H O L L A N D
DISTRICT COUNCIL

Application no: H18/0665/00

Description: Erection of two houses with
associated parking.

Location: Land adj. 1 Youngs Row
Sutton Bridge
Spalding
Lincs

ERECTOR OF TWO HOUSES WITH ASSOCIATED PARKING
ADJACENT No. 1 YOUNGS ROW
SUTTON BRIDGE
Lincs
For PREMIER BUILDERS (South Lincs) Ltd
10 OCTOBER 2000
11 DEC 2000
0665460
APPROVED PLAN
Full Planning Permission: 11/00065/000 dated 04/08/2000
Building Regulation amendments: B1/00063/000 dated 16/11/2000

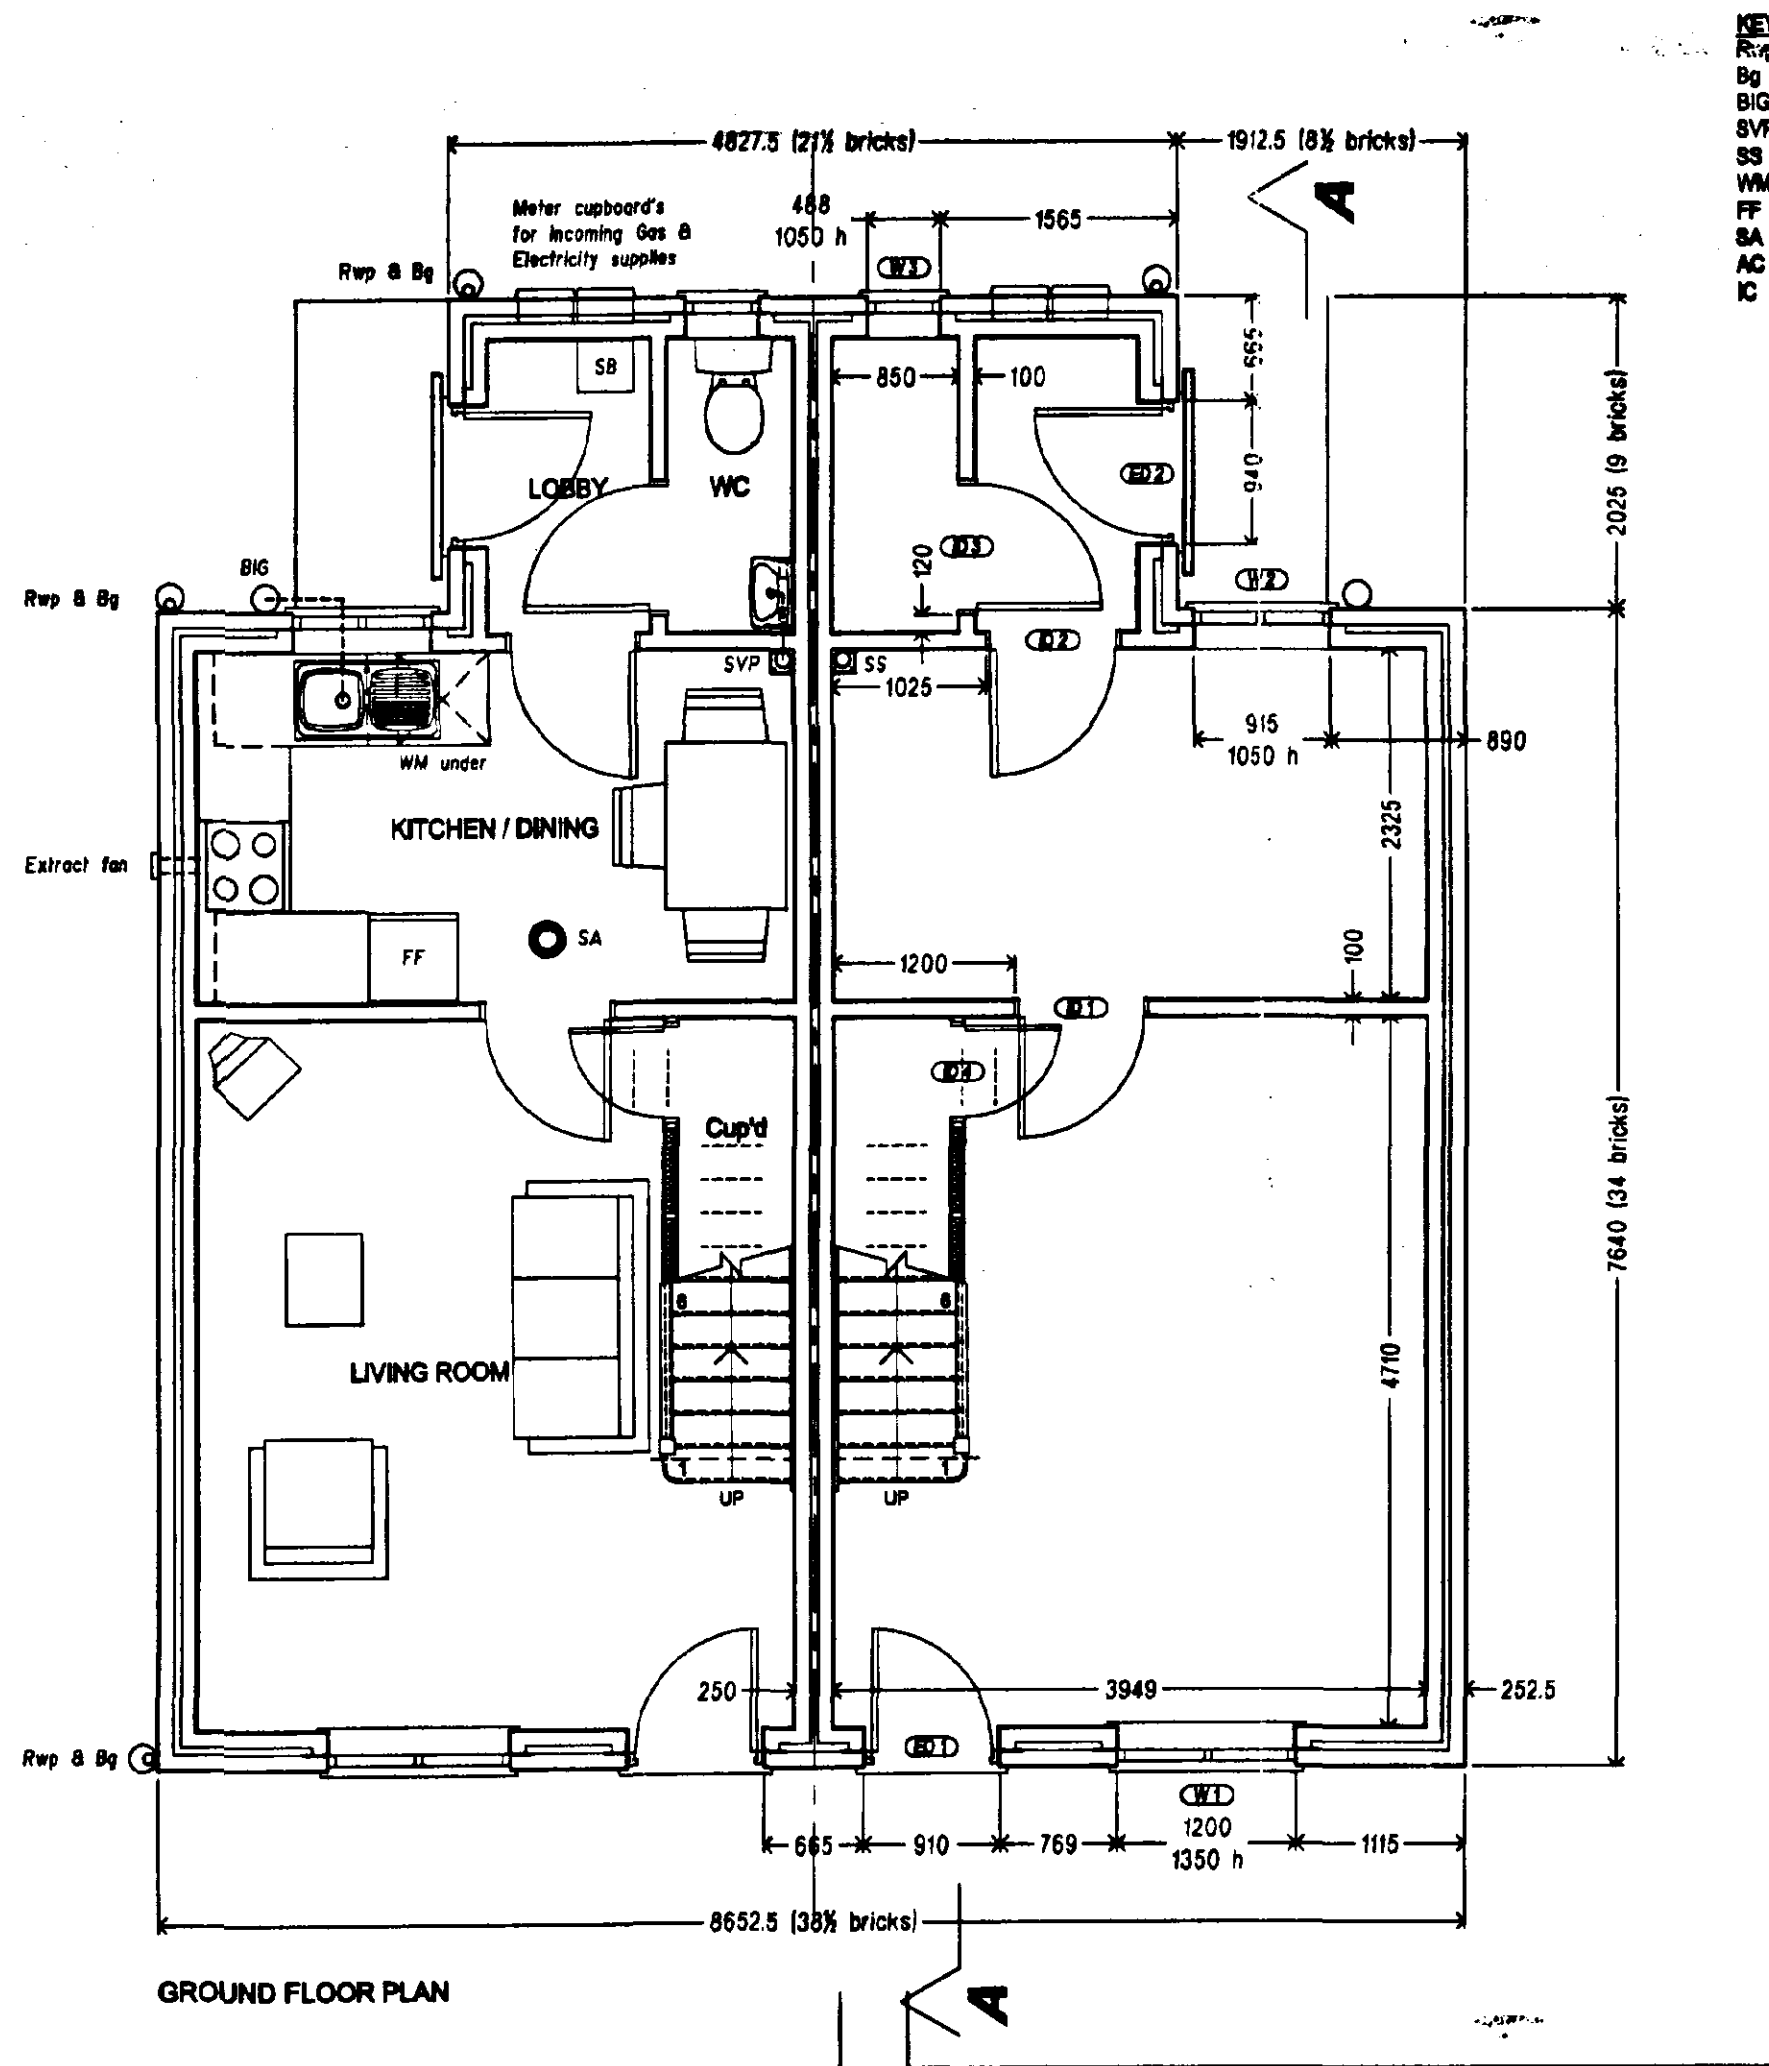
Amendment: Windows moved from north to east and west elevations

The amended details submitted in respect of the above proposal have been received and I consider that the changes are too significant to be treated merely as an amendment. A fresh application will therefore be required (forms enclosed). This does not imply that permission will or will not be forthcoming for any such revised application.

We bring to your attention that the windows which were originally located on the rear elevation, i.e. North, have been moved to the East and West elevations. This is due to revisions that had to be made to comply with the current Building Regulations, for 'escape windows'. The windows to both the Living Room and Bedroom No.1 have been altered in size to accommodate these requirements.
